**From:** [Bill Booker](#)  
**To:** [A38 Derby Junctions](#)  
**Cc:** [Simon Cope \(simon.cope@eurogarages.com\)](#); [Tim Hancock](#); [Wilson, Andy](#); [Rob Green](#)  
**Subject:** A38 Derby Junctions Schemes  
**Date:** 26 March 2020 08:42:32

Following the postponement of the Hearing on 19<sup>th</sup> March we have, as requested, prepared an update for the Inspector in relation to the issues raised by Euro garages Ltd (EGL). This note has been prepared with input from Mr Tim Hancock and also Mr Simon Cope from EGL. The outstanding issues raised are summarised below under the following headings:

1. A52 access junction
2. A38 Ingress to the site
3. A38 Egress from the site
4. Advance Warning Signage

DELIVERY TRACKS

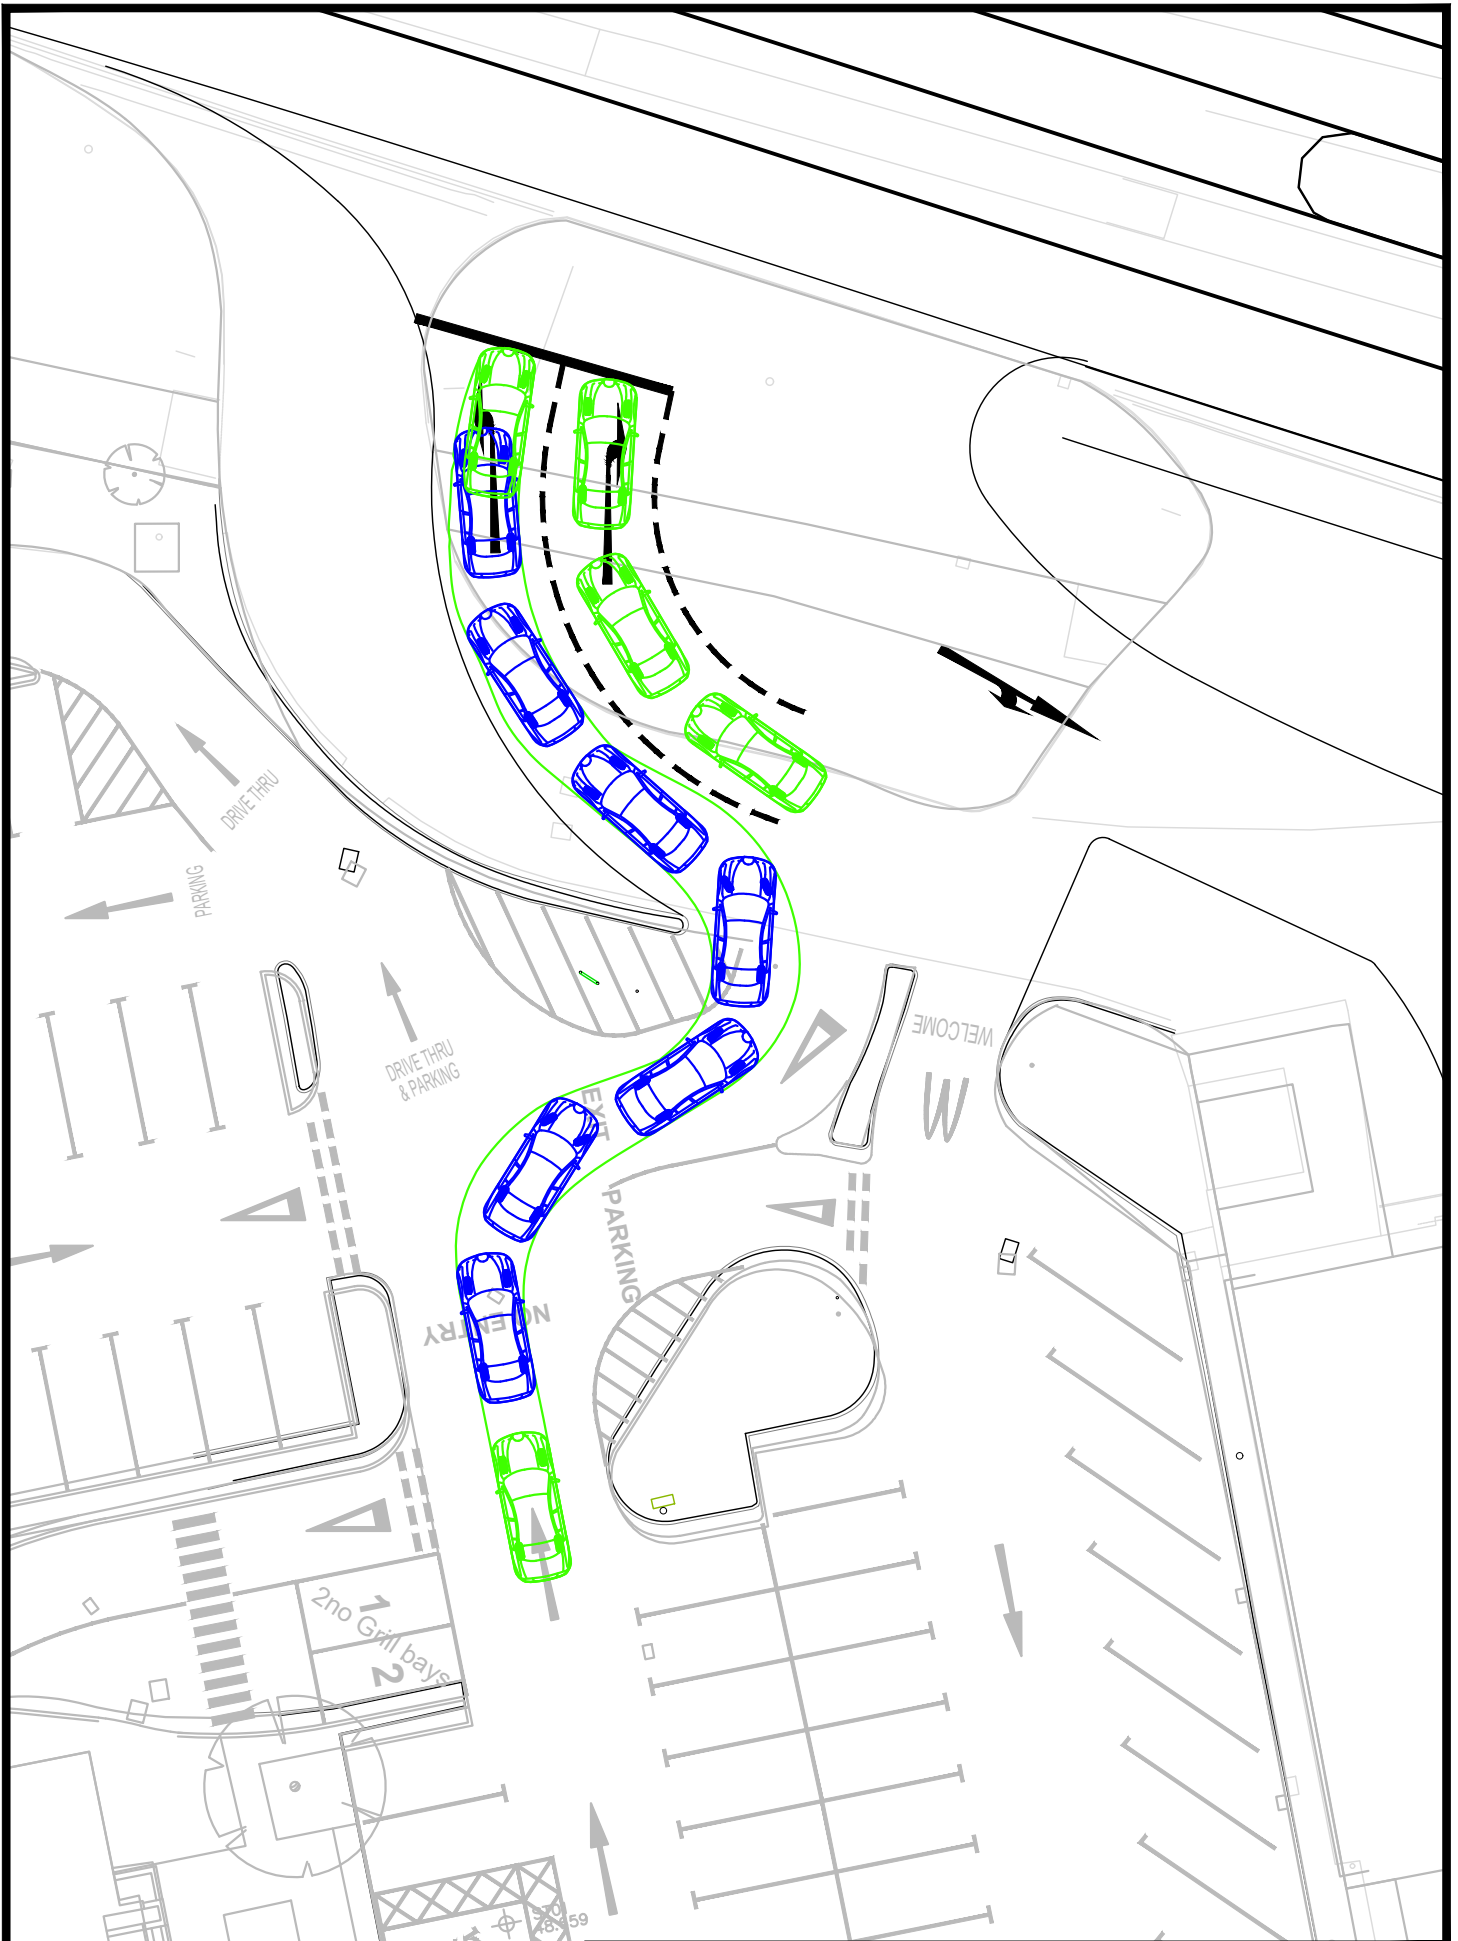
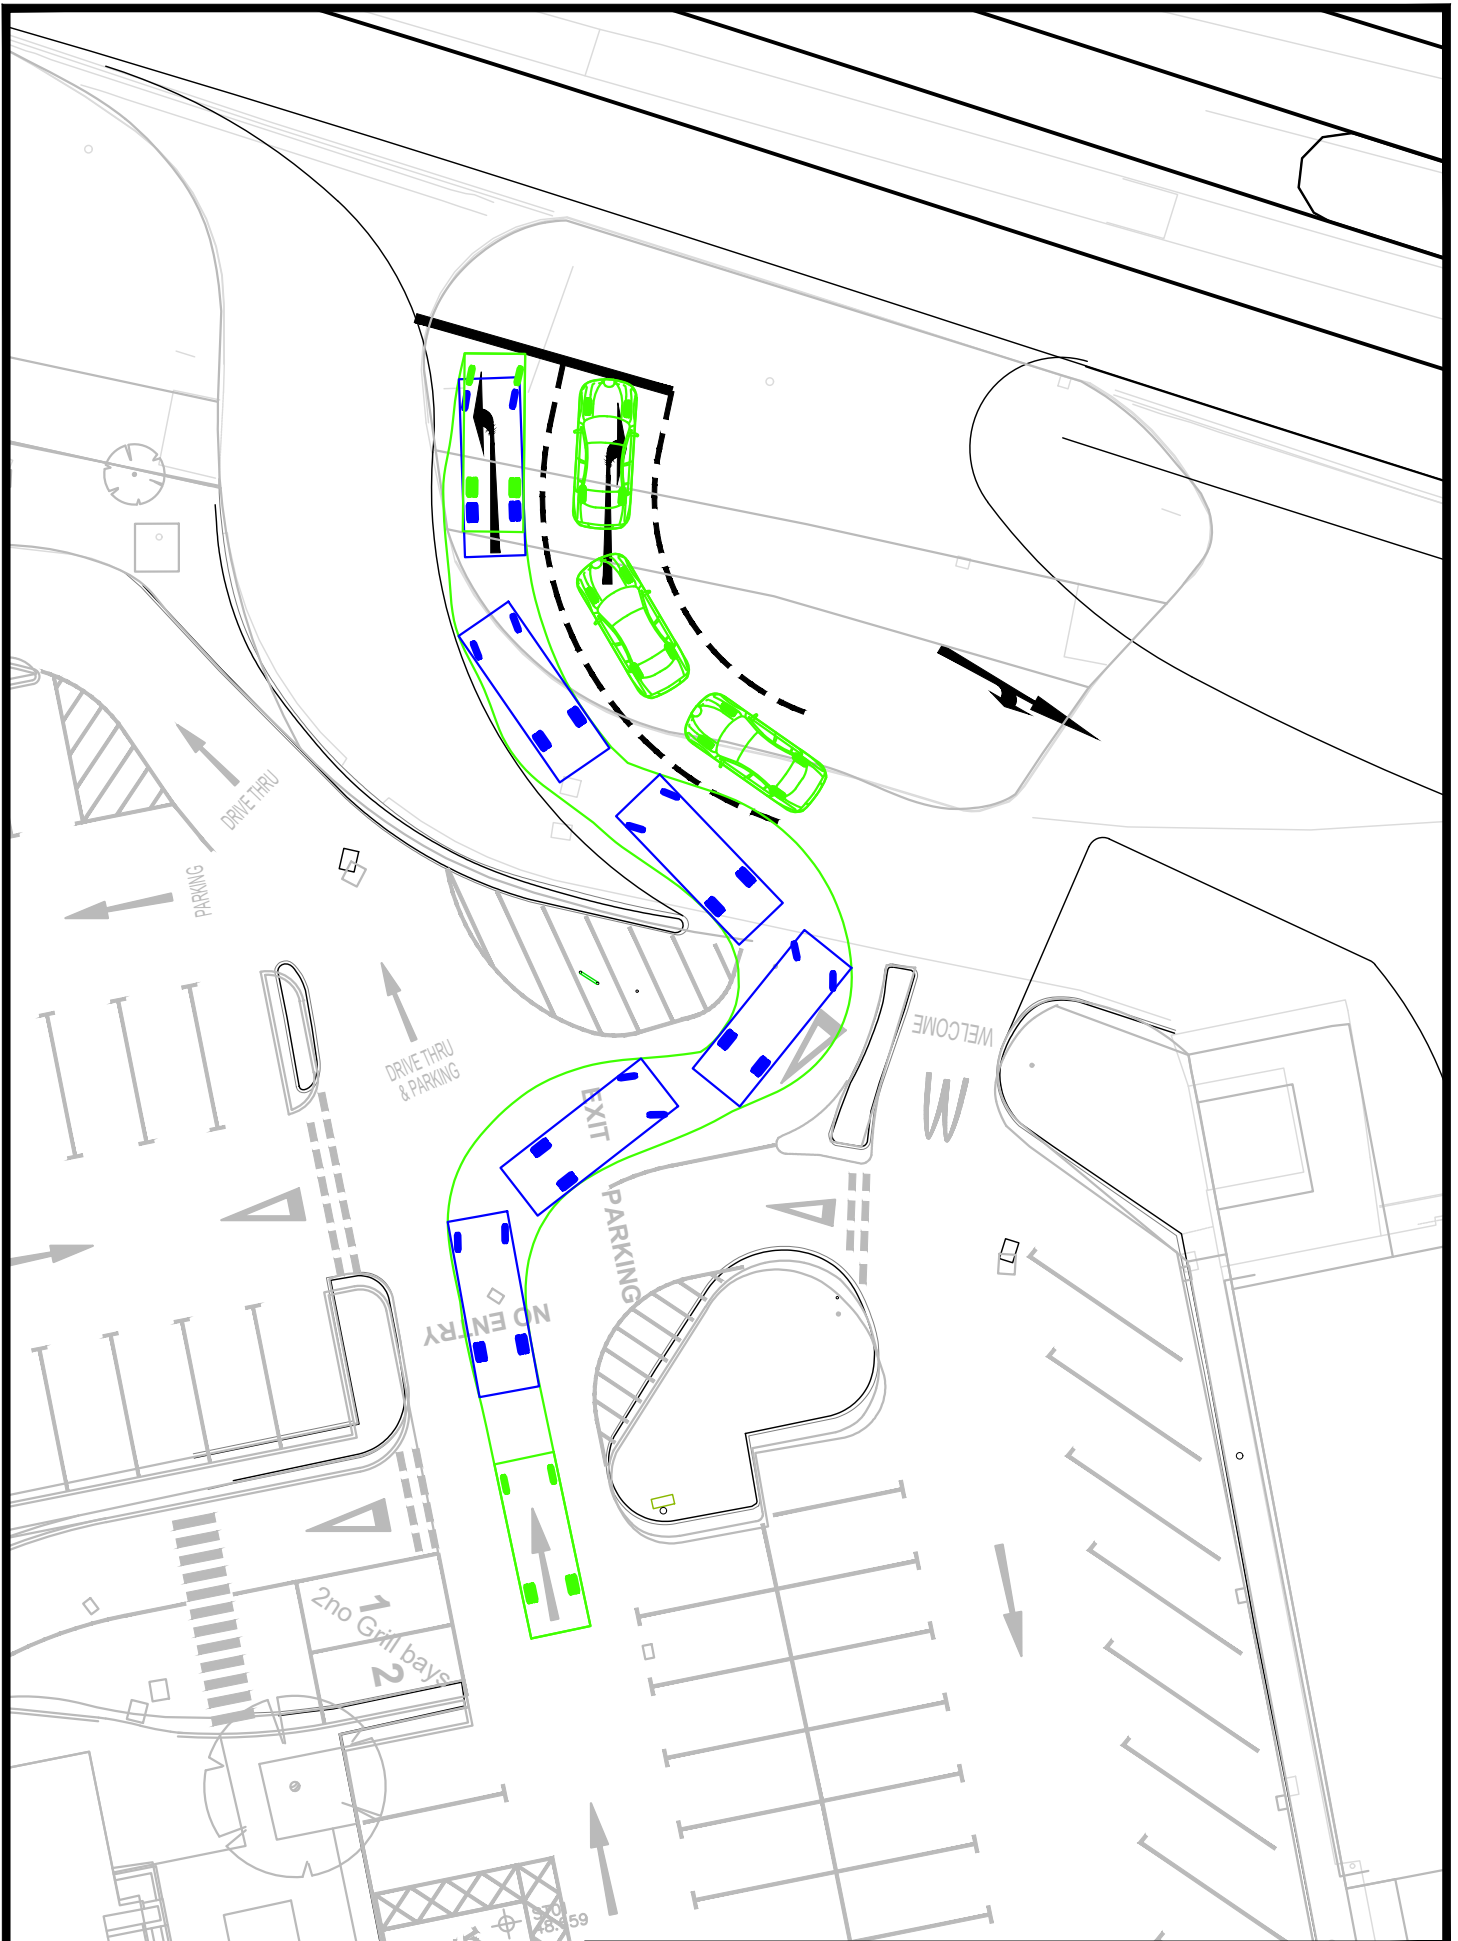
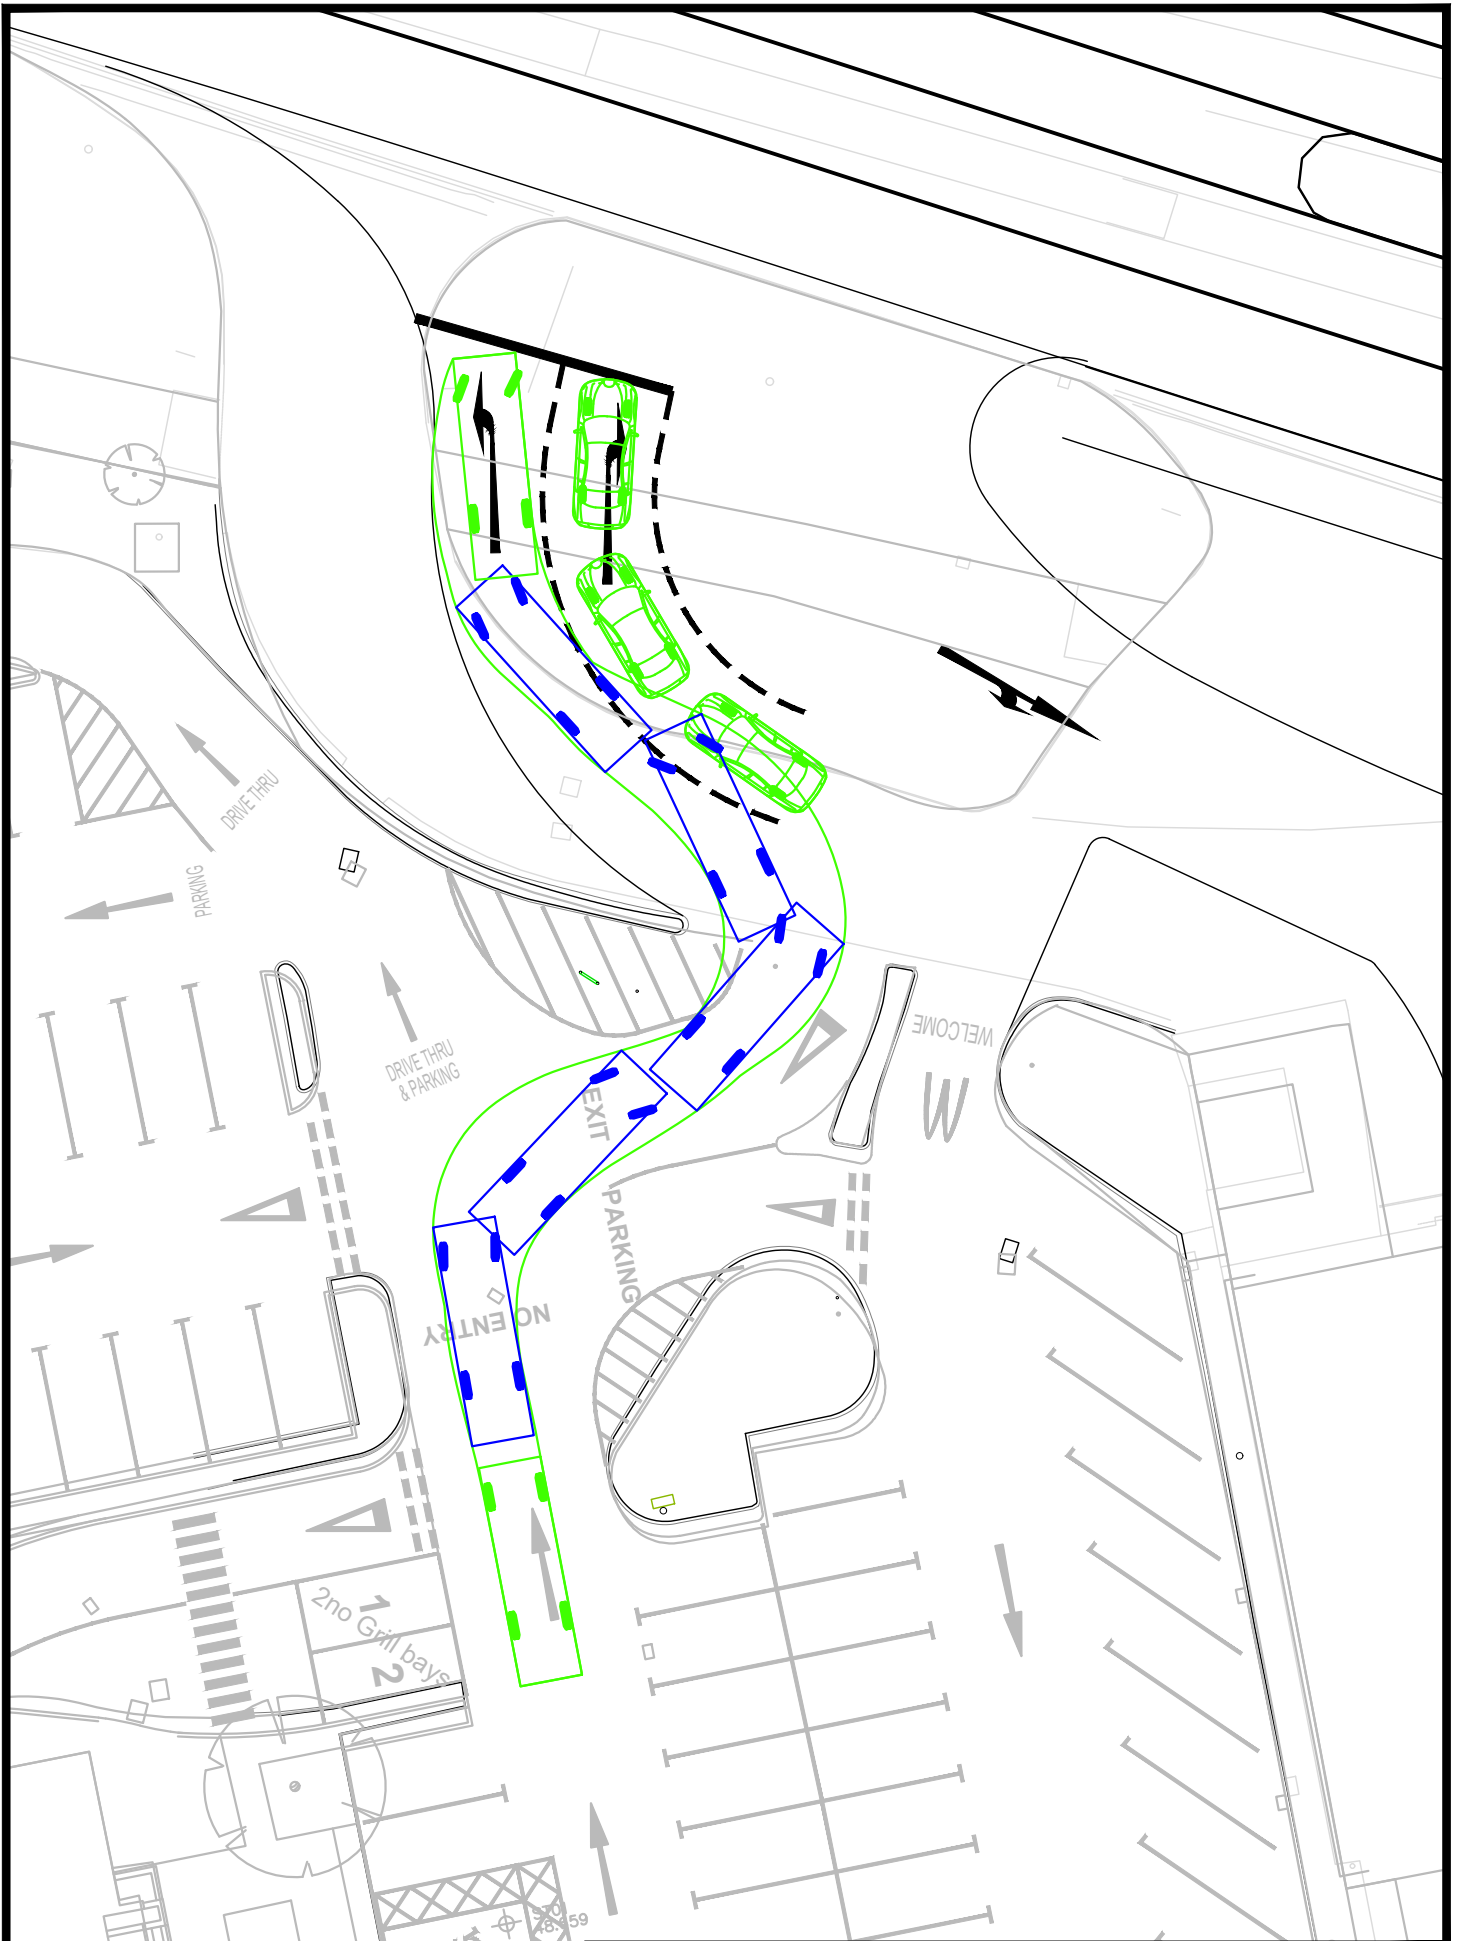
3. The McDonalds delivery / refuse manoeuvres will no longer be able to take place from the A38 and will have to pass through the existing car park using the sub standard A52 access. The swept path of the delivery vehicle illustrates that the vehicle will need to pass onto EGL land in order to make the manoeuvre. No allowance for this new right has been made in the DCO. It is not considered appropriate to rely upon McDonalds and EGL to have to come to an arrangement on this matter. **This point needs to be clarified by the Applicant.**
